Date: 16/04/2020
Our ref:
Your ref: TR010056/S42(1)(d) further land interests

David & Lisa Field

Your ref: TR010056/S42(1)(d) further land interests
A417 'Missing Link' - Planning Act 2008 Sections 42(1)(d) and 44 - Supplementary Consultation

Drawing Title: **FIGURE 13.19 SCHEME HIGHWAY DRAINAGE - PLAN**

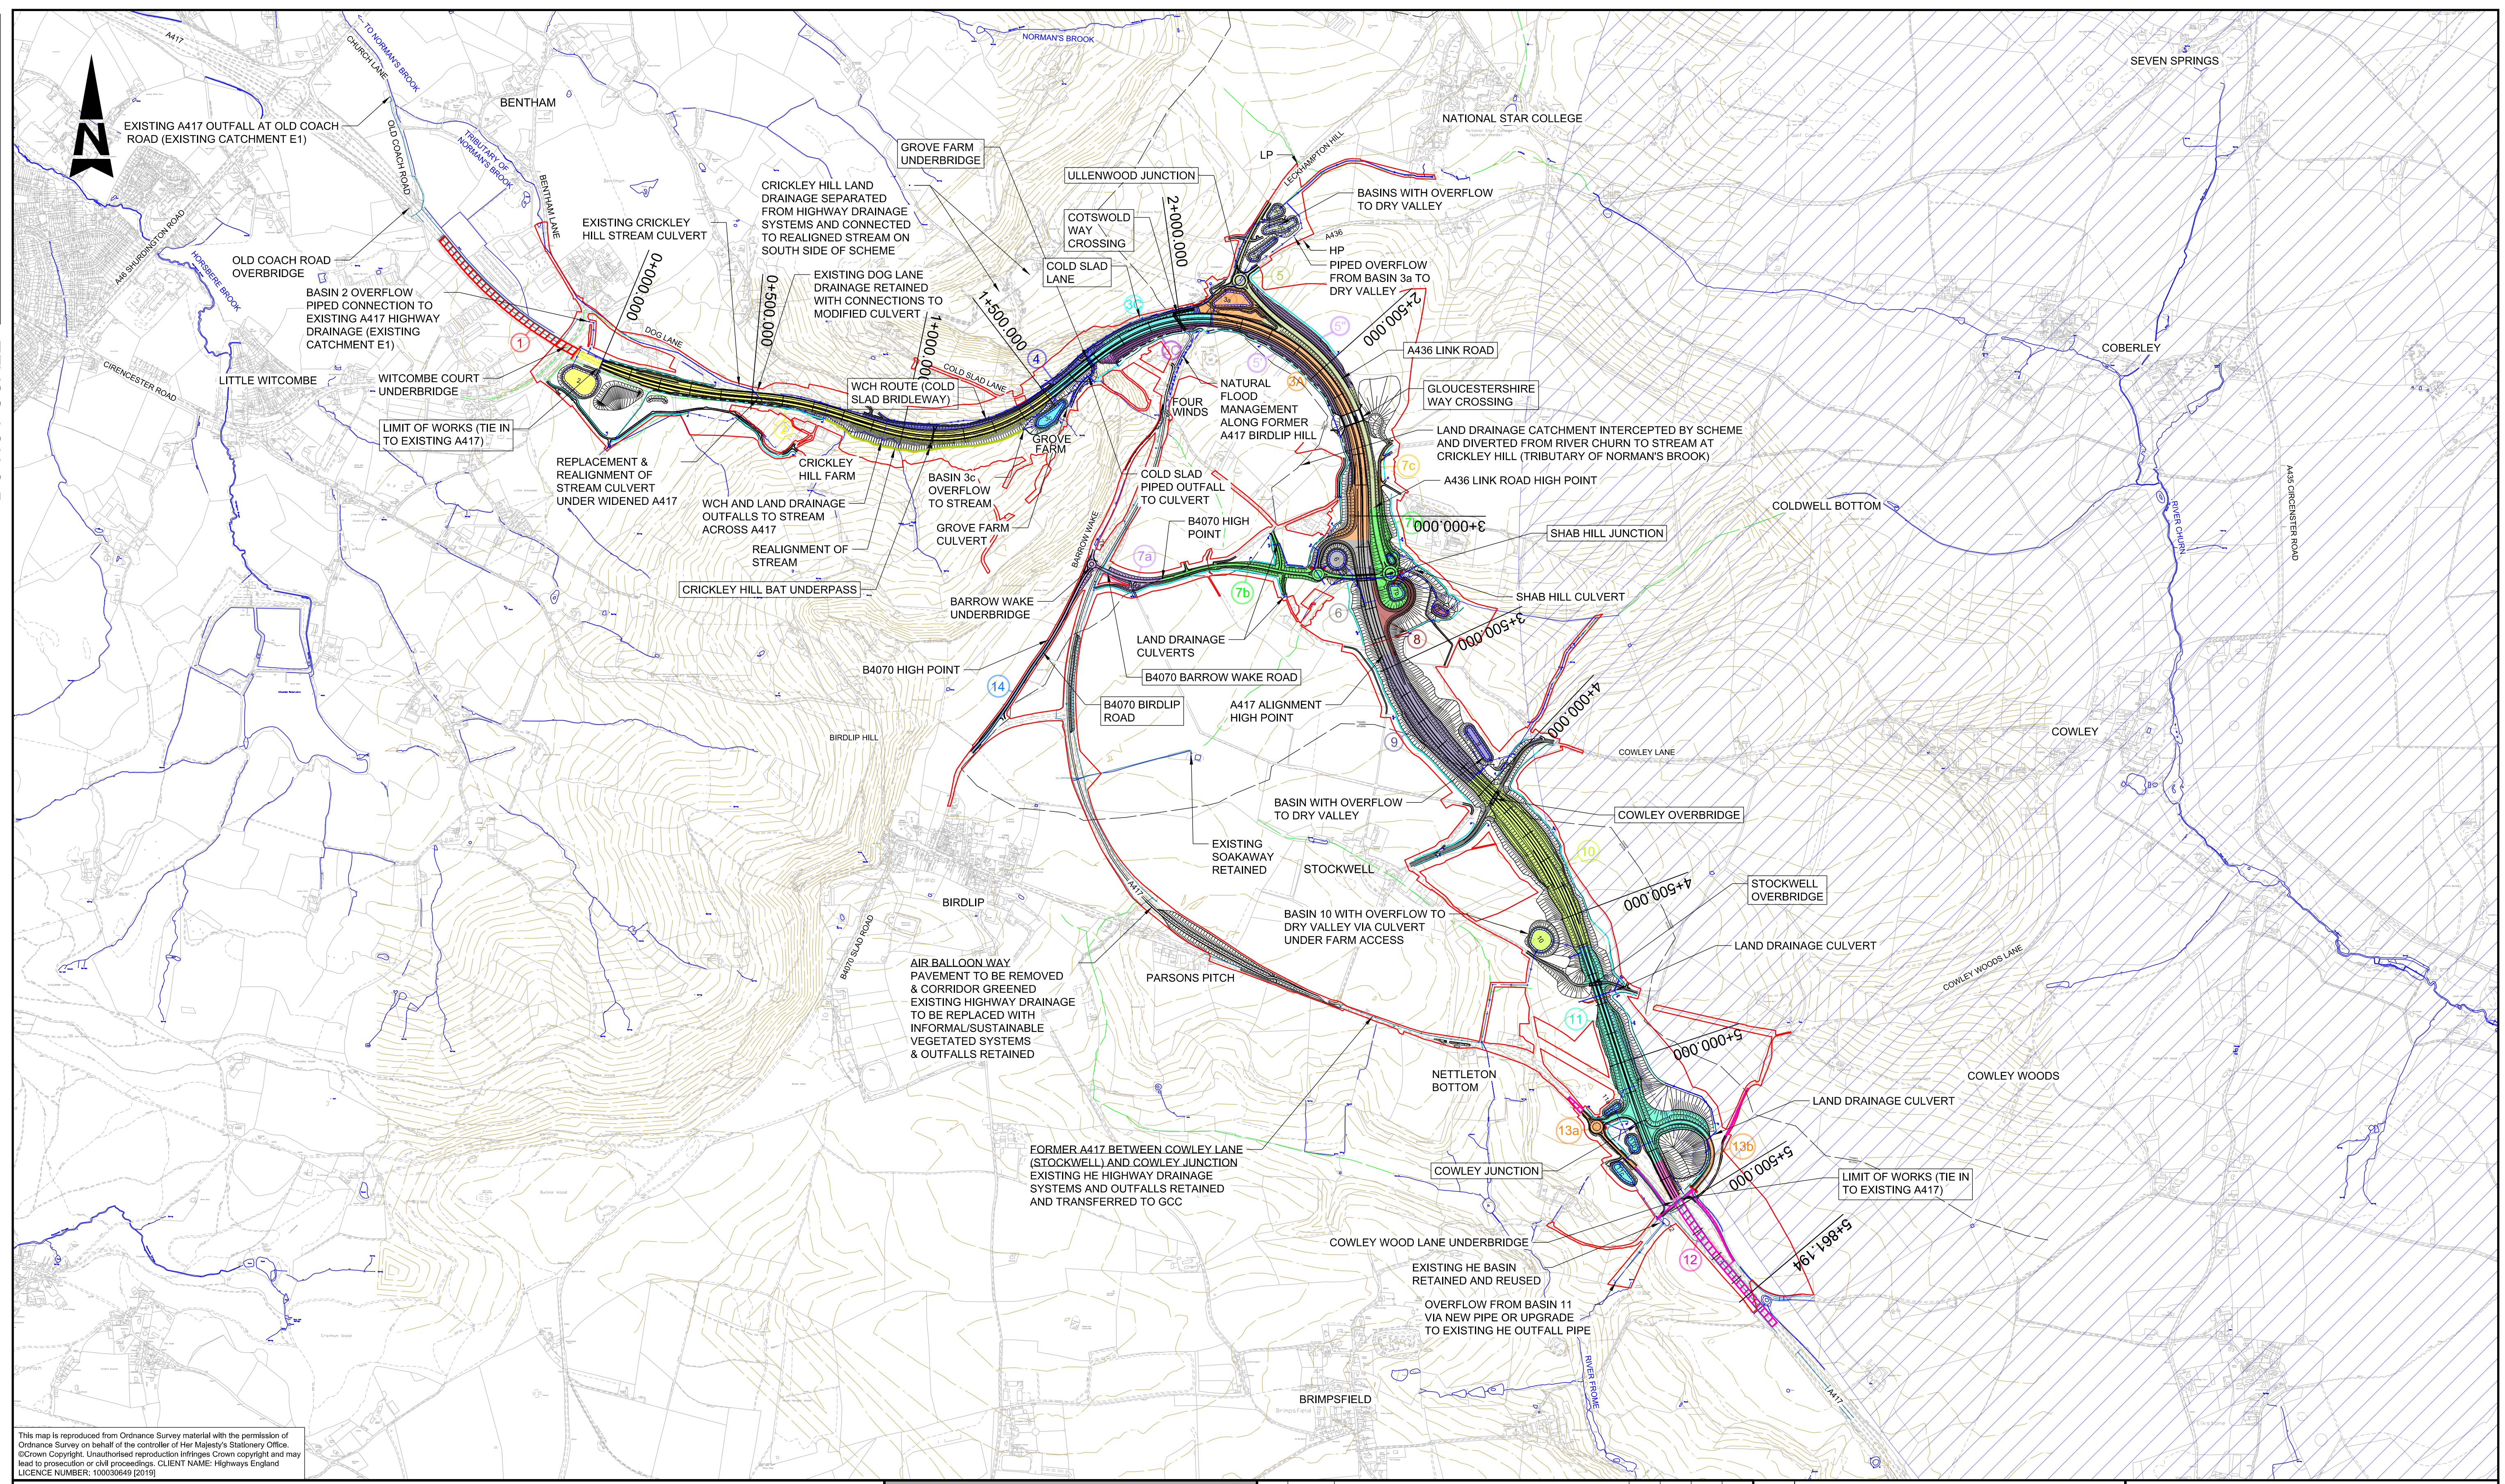
The main issue currently is the fact you're looking to cut directly across our property and cut it into 2 sections by placing the drainage pipe straight across. This will cause serious damage and disruption to our services including Gas Supply, Septic Tank and Herringbone Drainage. We appreciate your covering letter mentions these factors and that this consultation is primarily to cover only the additional land you're looking to obtain from us, however, we have not had a meaningful response from anyone at the project concerning this. It is therefore difficult for us to comment on the additional proposals when the core of the issue has not been resolved, or even addressed properly. It leaves us feeling that if there has been time given to this part of our home for these recent changes, surely there must have been time to consider the other aspects that we brought to your attention. That you appear to be intent on proceeding with the indicated route gives the impression that our comments have not even been considered.

As we have indicated previously, we are willing to discuss and negotiate a more suitable route so the pipe can run around the boundary of the property. Indeed, different options were discussed at our last meeting on the 6th February 2020 but again, we have received no meaningful response of justification as to why the route cannot be amended. We have to make it clear that we DO NOT agree in any way to the current route coming straight across our home, especially when other more suitable options are available.

As explained, the current land take proposals are unacceptable. Both the temporary occupation for construction and the lasting maintenance rights will cause severe damage and disruption to our property. A more suitable route will help mitigate this. Once a solution to the drainage pipe has been agreed, we will be able to comment on the land take further.
